CITY OF ALBUQUERQUE

April 16, 2022

Re: Sequoia Apartments
5130 Sequoia Rd. NW
Traffic Circulation Layout
Architect's Stamp 02-25-2022 (G11D058)

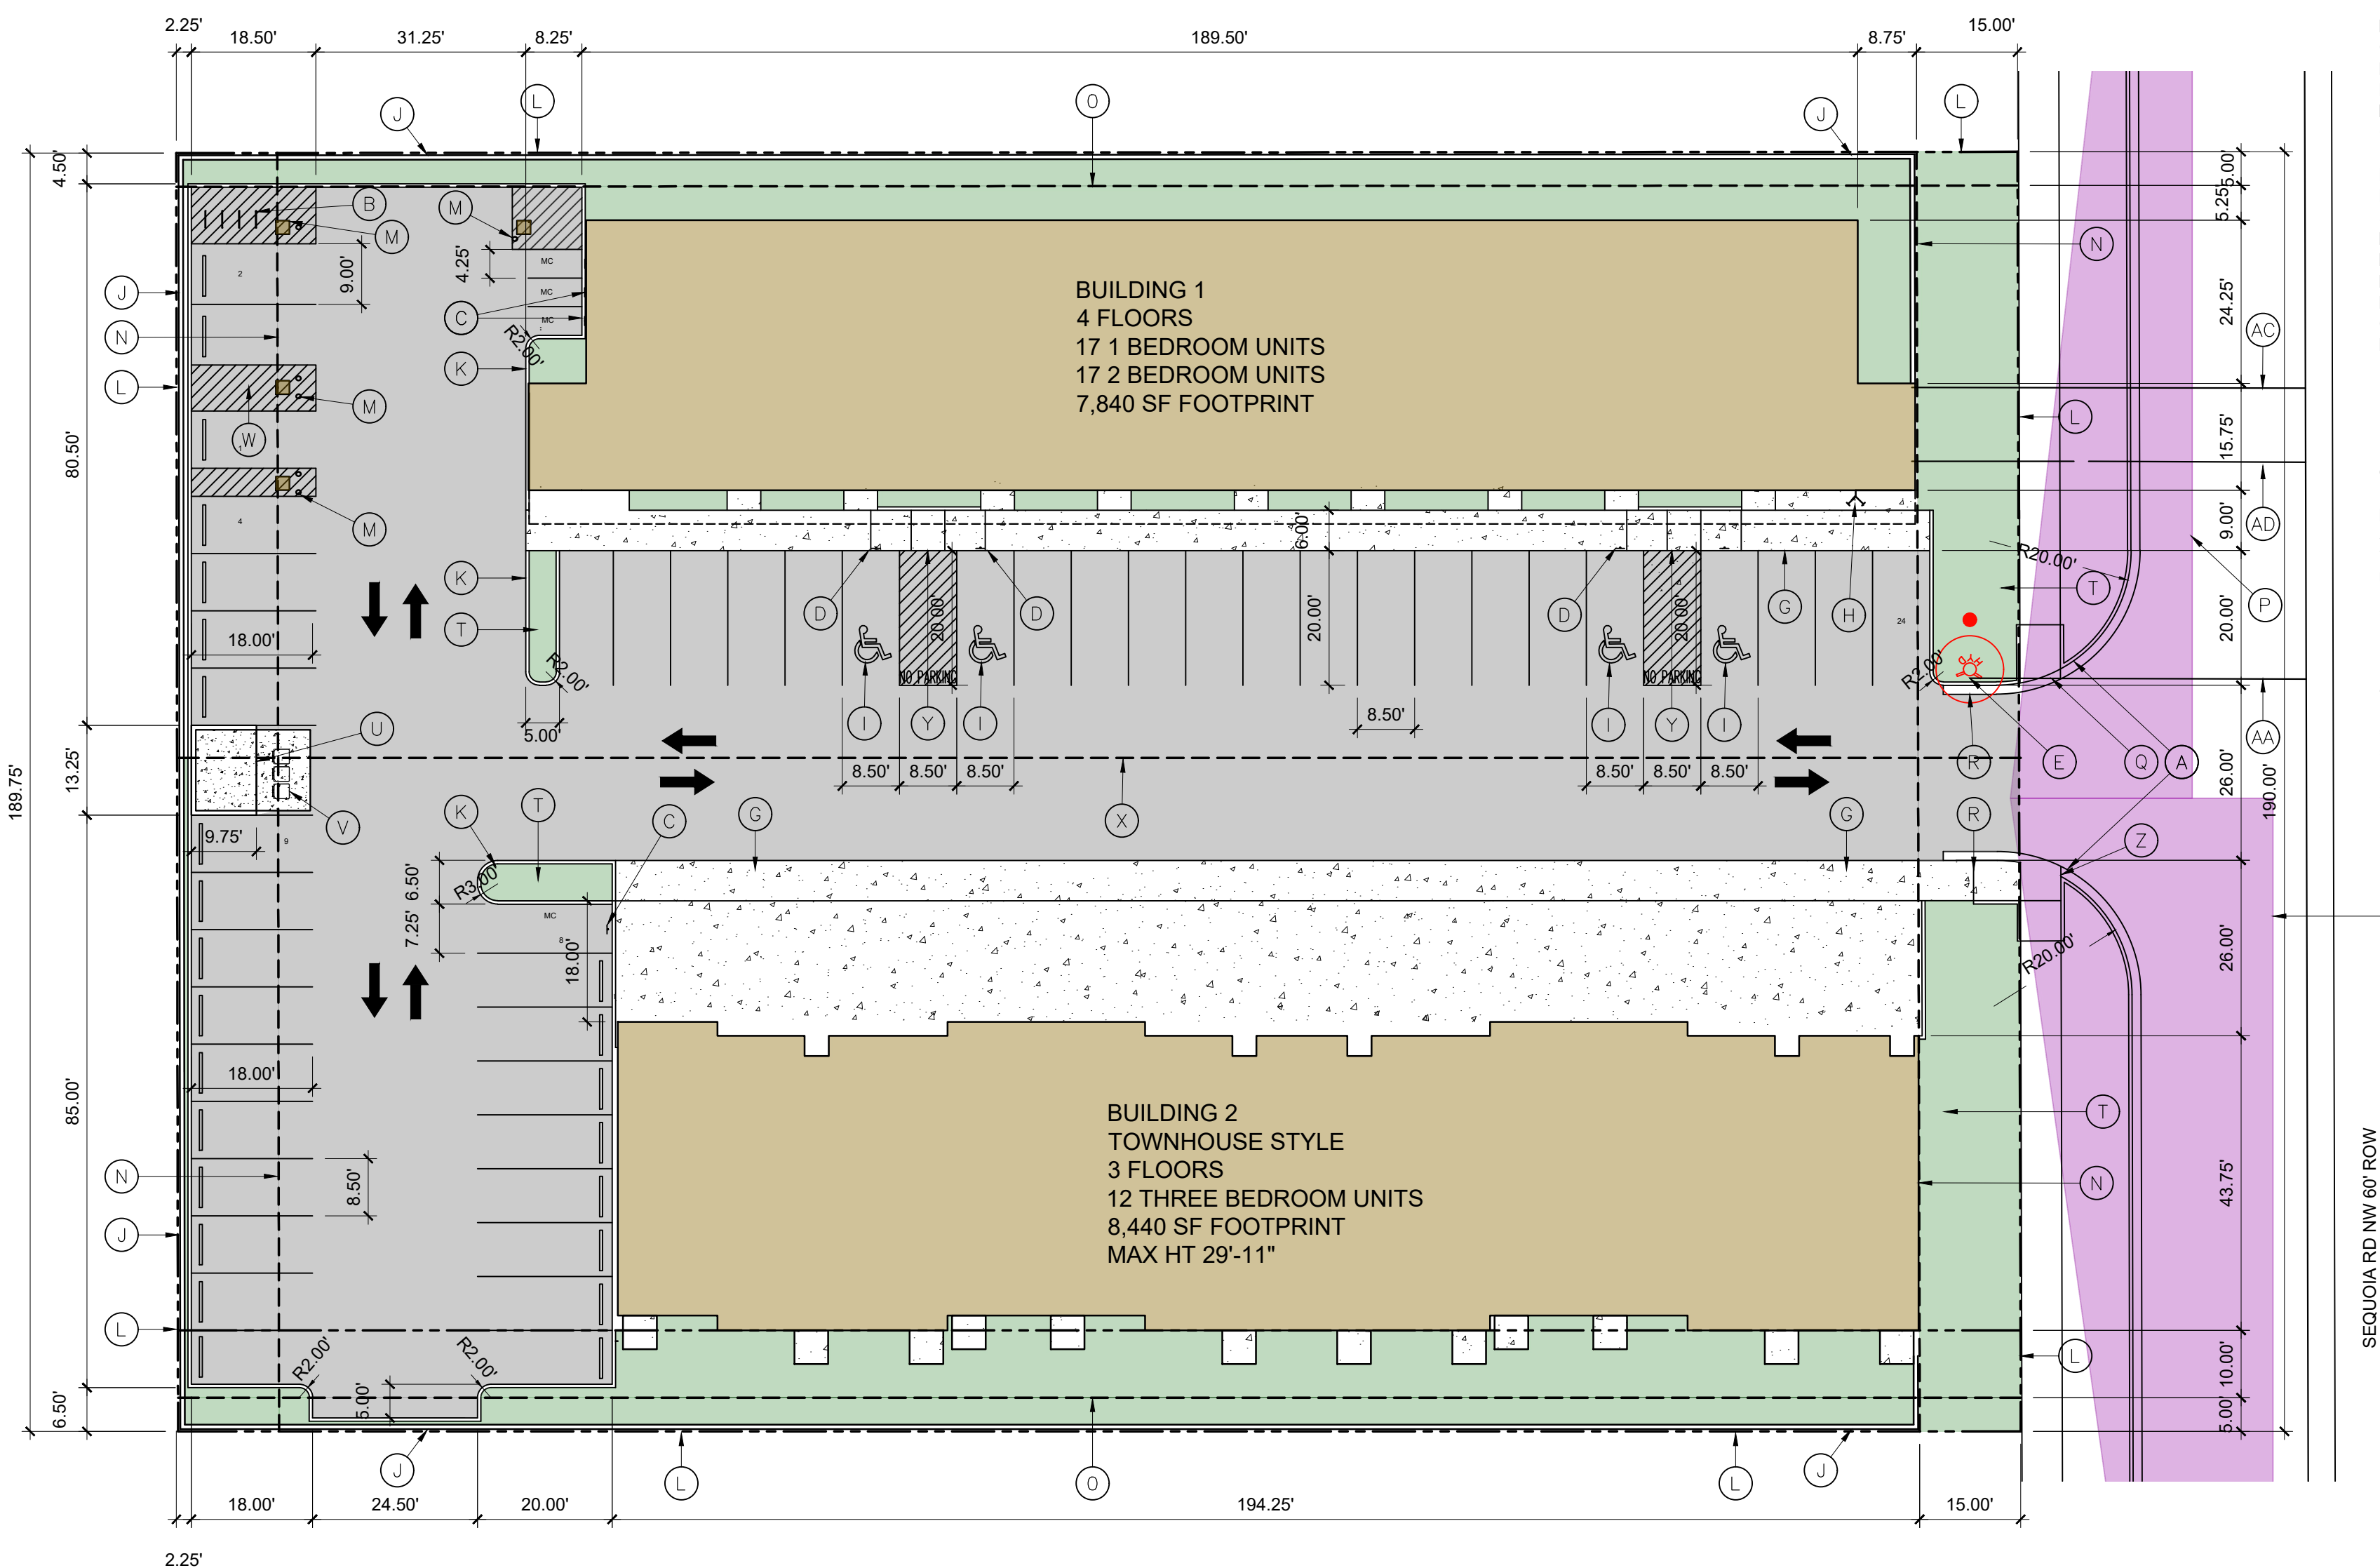
1. Proposed Entrance-Western Leg (Sequoia frontage):

- Your proposed 6ft ADA pathway and ramp are in conflict. A tripping hazard is being created by parallel layout of both infrastructure next to each other and side slopes are being compromised. Please offset 6ft pathway to avoid this safety concern. This is not ADA compliant. **Keyed Note Z: Try COA std dwg 2444, Detail D**

2. ADA parking stalls:

- **Details will be needed for proposed striping and pavement marking** (NO PARKING text). **Still need DETAILS (Not addressed)**
